Final Acceptance Punchlist

El Paso County – Department of Public Works – Stormwater Section

Project Name:	Widefield Park & Rec Improvements
EDARP File Number(s):	PPR2213, CON2261, ASB2316
ESQCP Number:	ESQ2250
Attendees:	DPW SW: Ben Jones DPW Development Services: N/A Developer: David Gish, Nuun Construction, Todd Kimes (LKA Architects), Jim Houk
Date of Walk-through:	04/08/2026
Walk-through Number:	1st

McNICHOLS® PERFORATED METAL

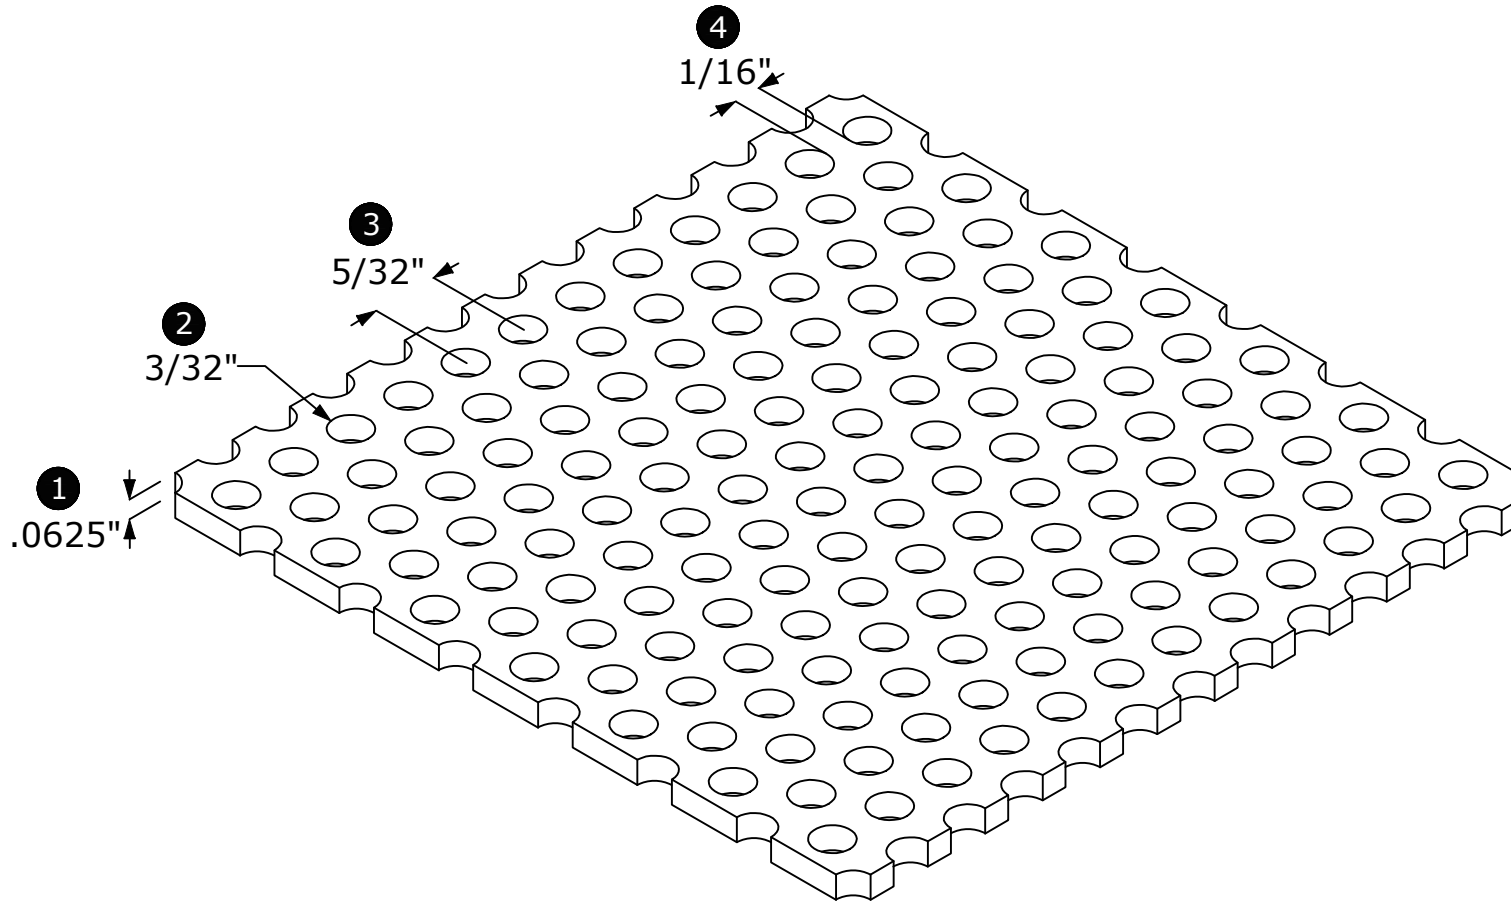
- Outlet Structure
 - Clean Trash Rack and repair lock mechanism. See photo 4.
 - Clean debris from Microscreen. Microscreen is a different material than called out on plans. Plans call for Johnson Vee Wire No. 93. Send updated detail on current screen material or replace per plans. See photo 5.

KHA Response: McNichols perforated metal screen is an acceptable substitution.
